Request for input to the Environmental Impact Statement for the St Marys Resource Recovery Facility (SSD-10474)

I refer to the request for SafeWork NSW to review and provide advice on the Environmental Impact Statement (EIS) for a Resource Recovery Facility at 25 Dunheved Circuit St Marys (SSD-10474). Thank you for the opportunity to comment on the proposed development.

6.4 Non-conforming waste suspected in stockpiles

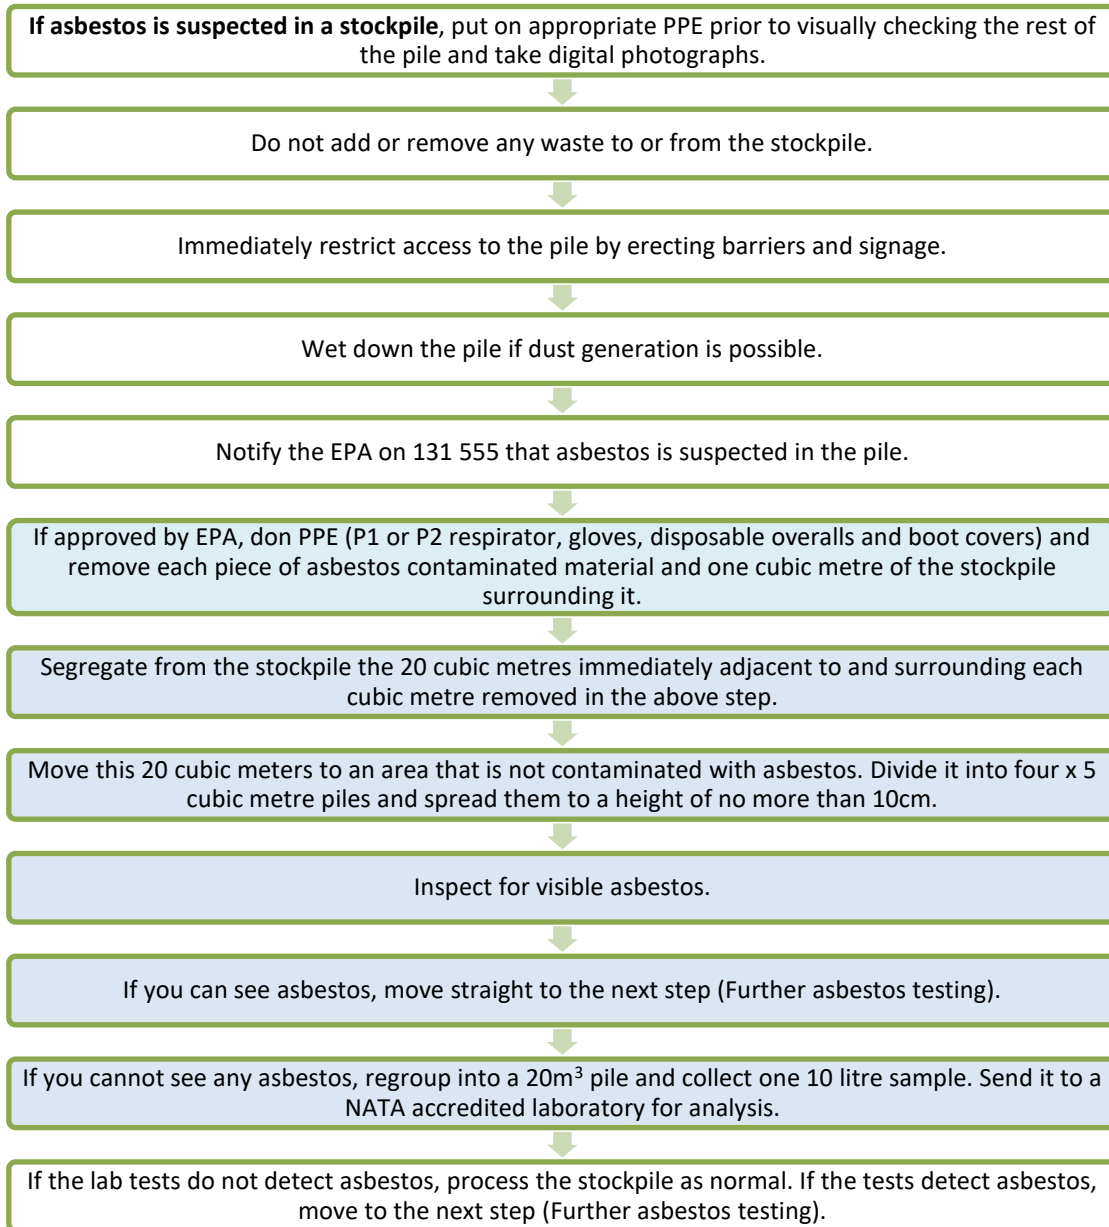
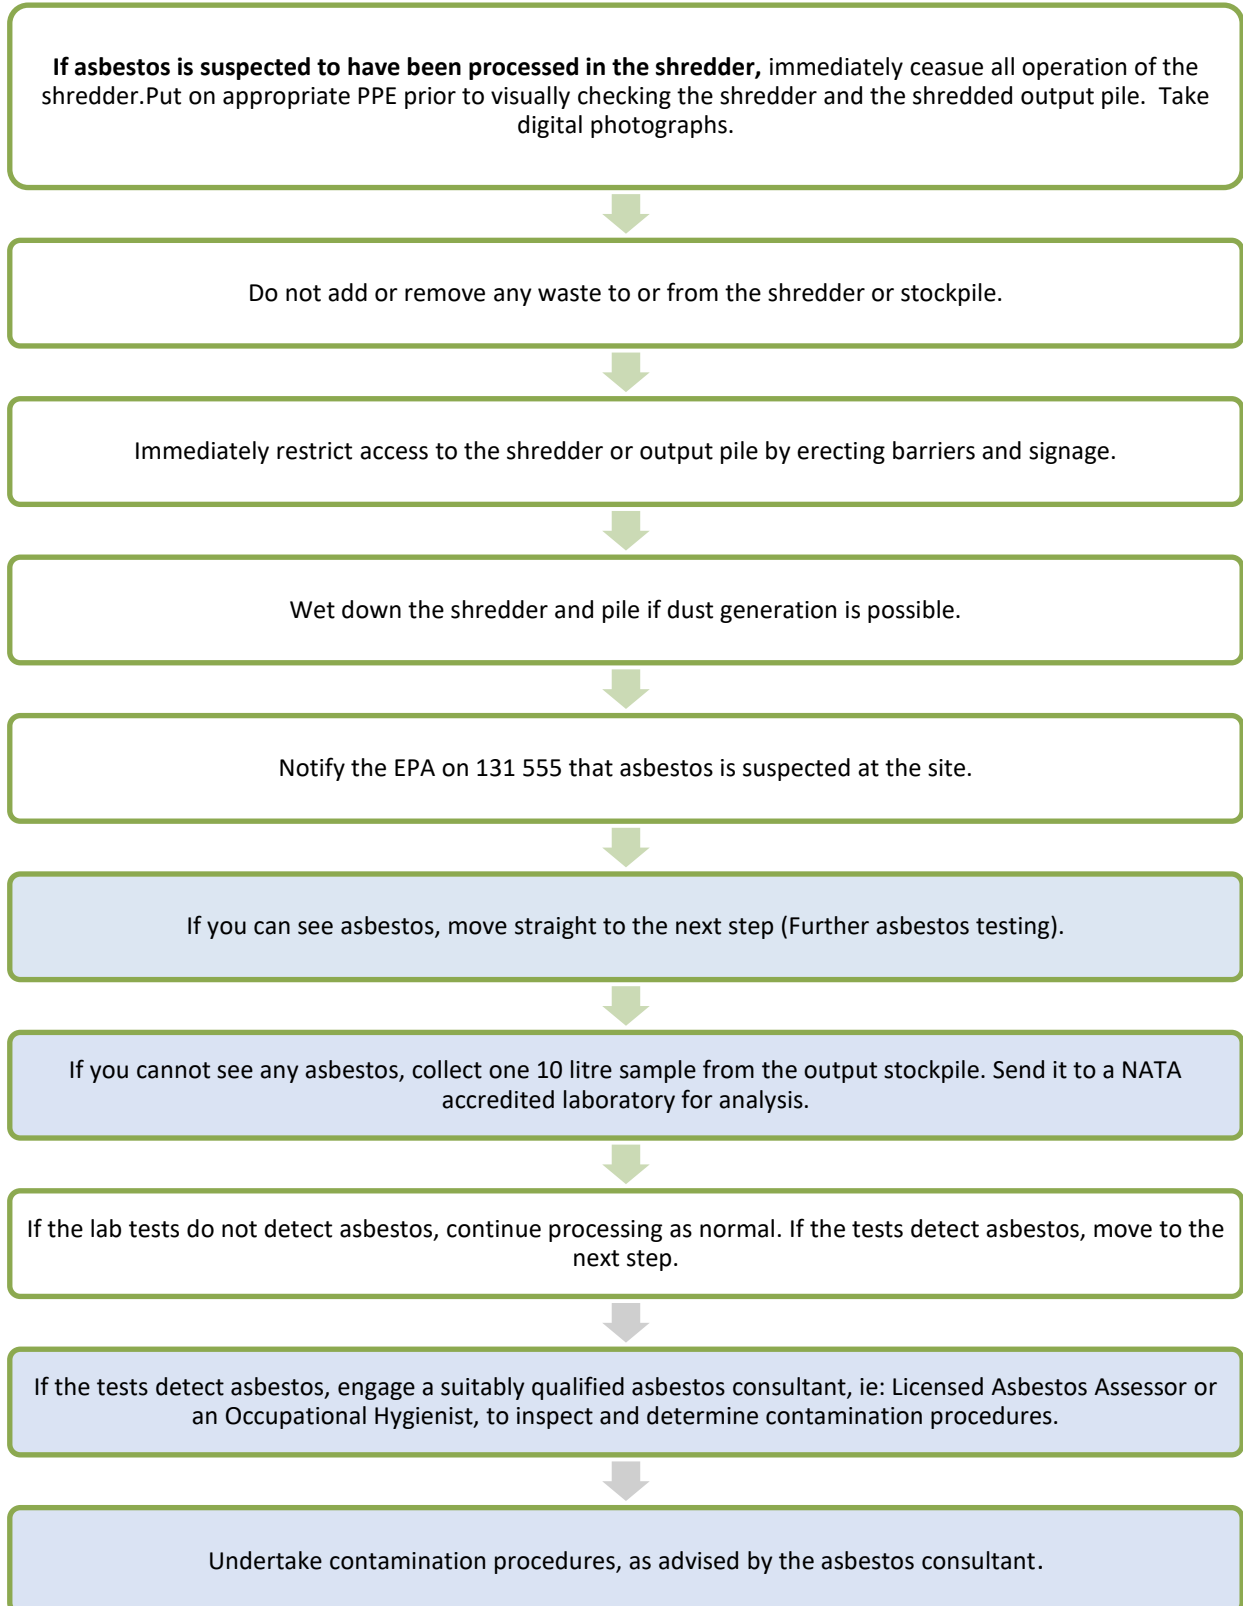
Sections 6.4, 6.5, 6.6 and 6.7 of the Non-Conforming Waste Procedure in Appendix A, refers to asbestos waste suspected in stockpiles. Sections 6.5 and 6.7 infer that these stockpiles are soil as the testing and sampling analysis is for soils.

- Review the above sections with regards to the term stockpiles as they relate to wood waste which the facility has proposed will be processed and not soil as listed.
- Develop a procedure for where asbestos is identified or suspected throughout the facility processes with regards to identification, safe handling, and suitable control measures.
